Application no: 3/2019/0930

Address: Clitheroe Light Engineering Upbrooks, Clitheroe

Proposal: Unit extension and new car park

PROPOSED SITE PLAN

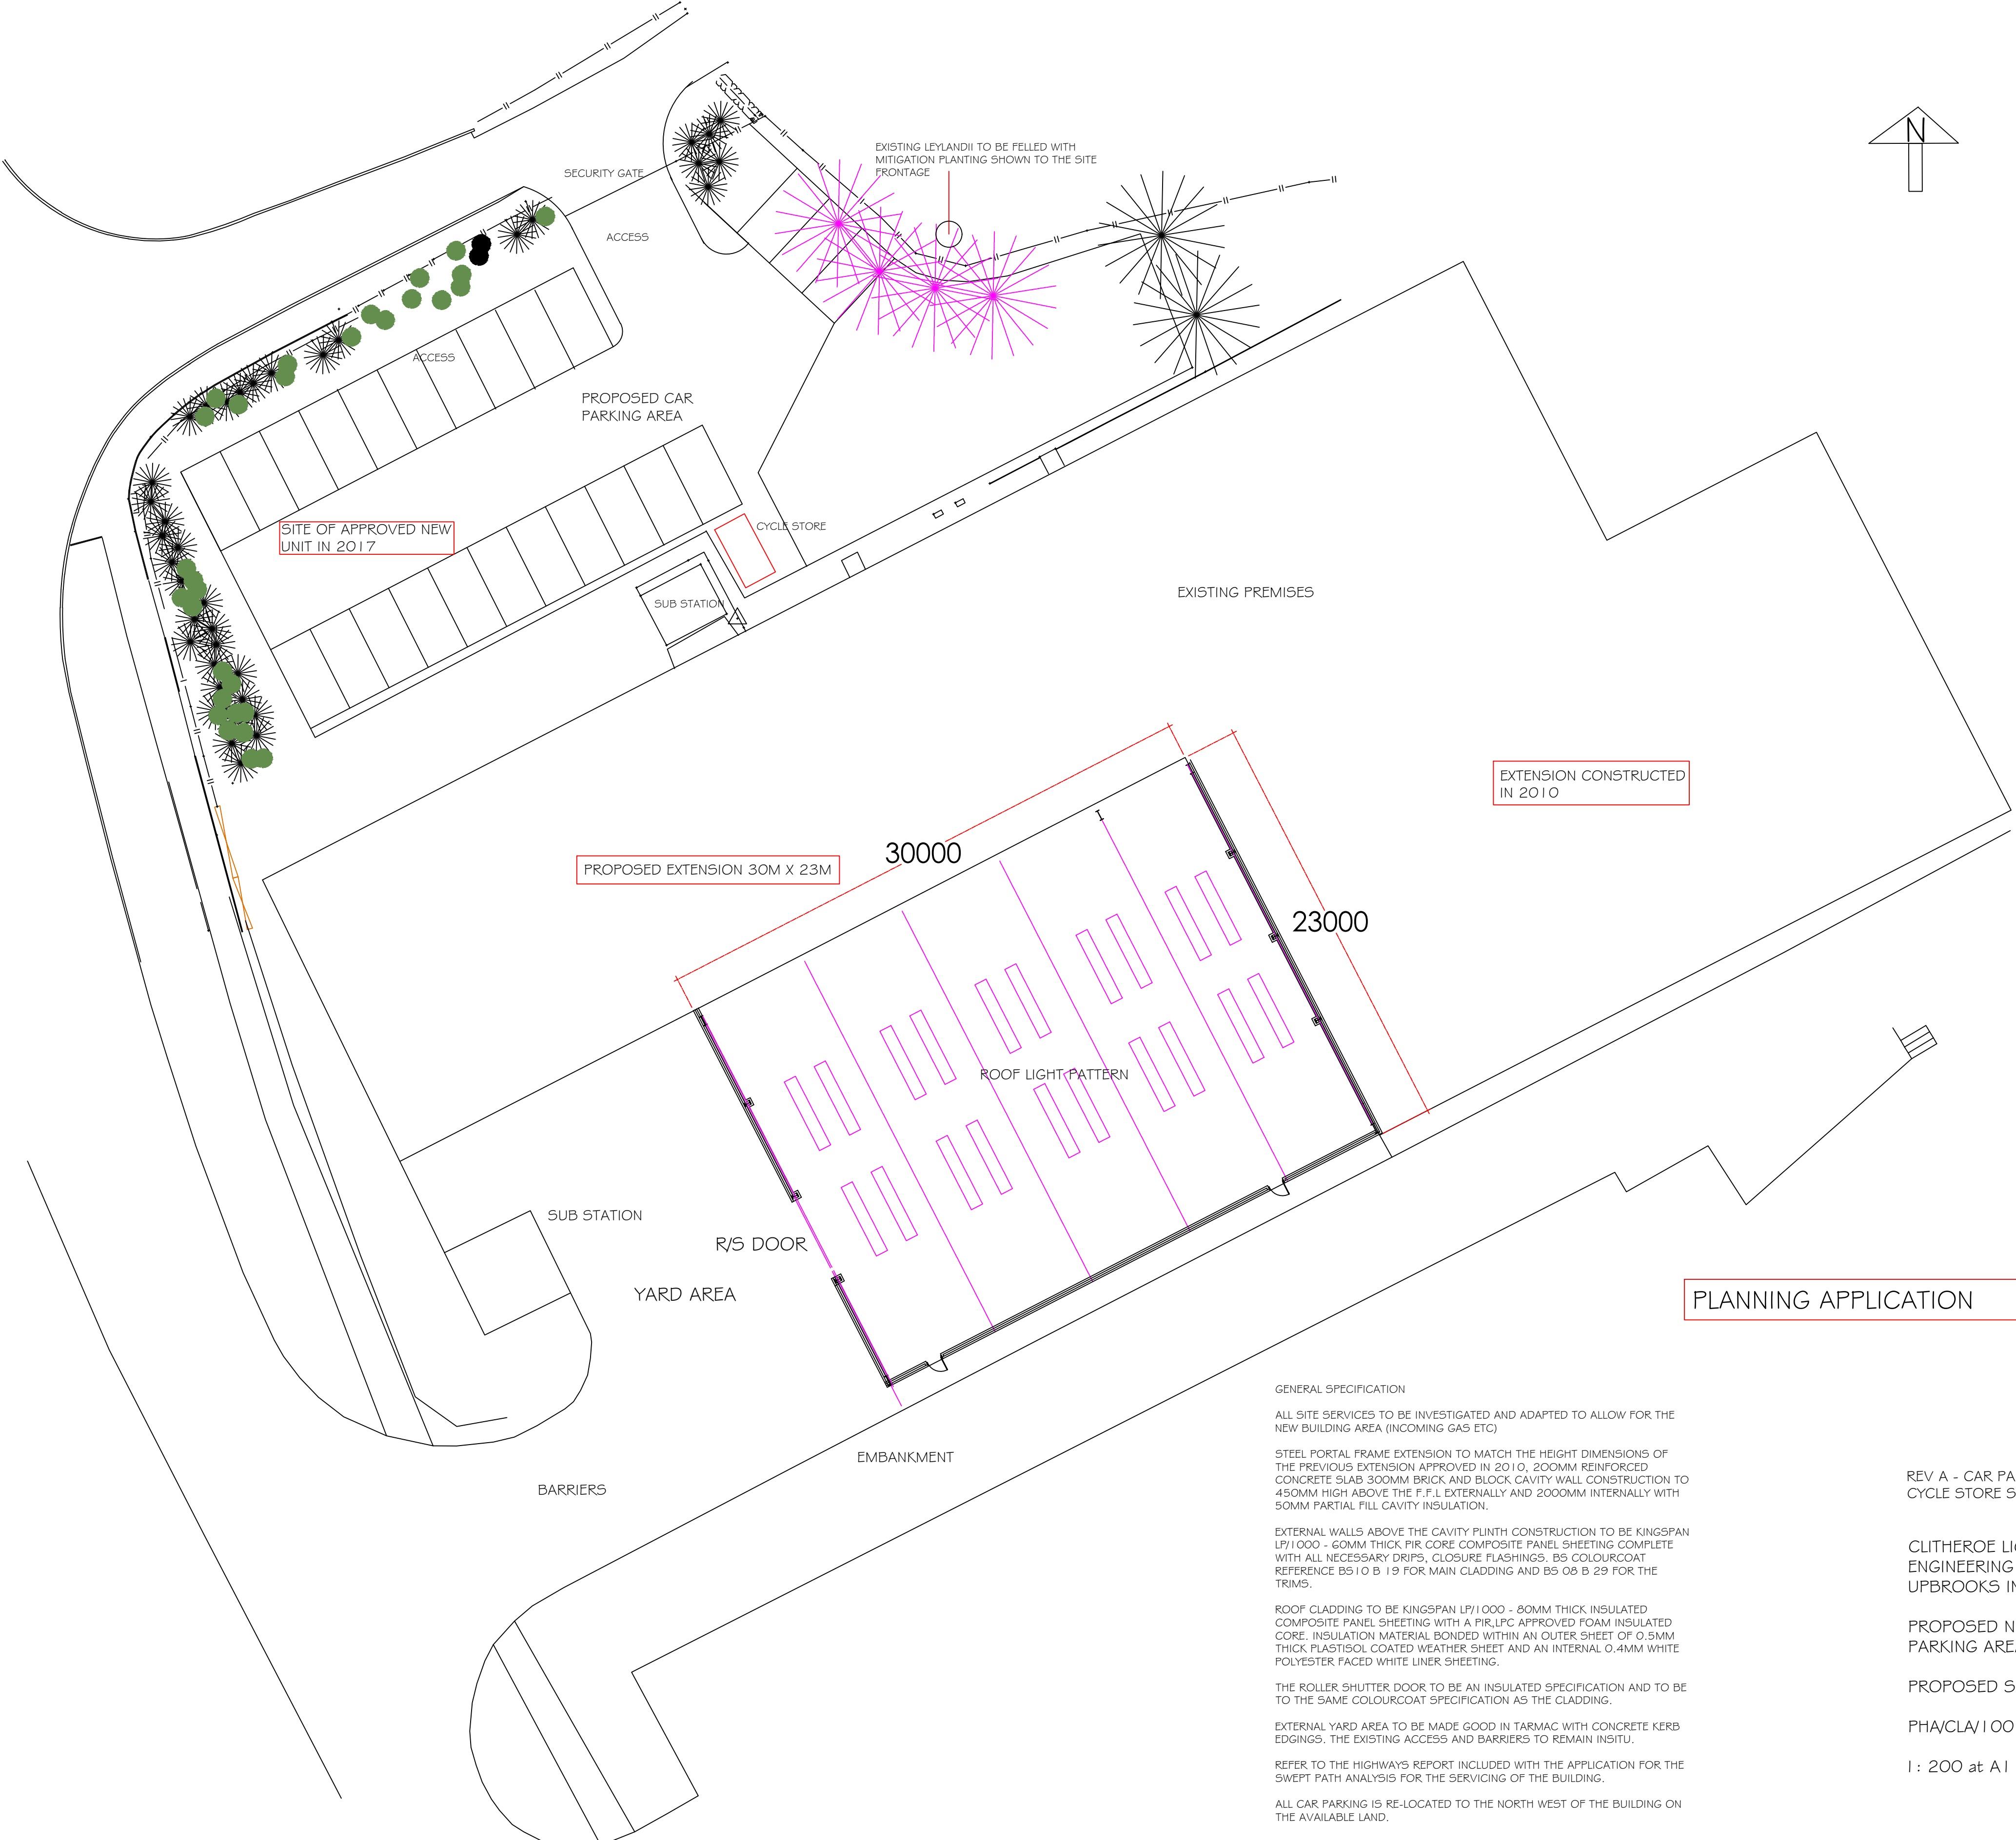
There is a application on Upbrooks (19/0840) currently under consideration which proposes a new car park with access opposite the location of the applicants proposed access. Notwithstanding the outcome of the 0840 application I would want the proposed car park access to be moved further east along Upbrooks to avoid any potential conflict. Subject to the receipt of acceptable revised plans, I would raise no objection to the proposal on highway grounds and should your council nbe mindful to approve this application I would request that the following Planning conditions and note be attached to any permission that may be granted.
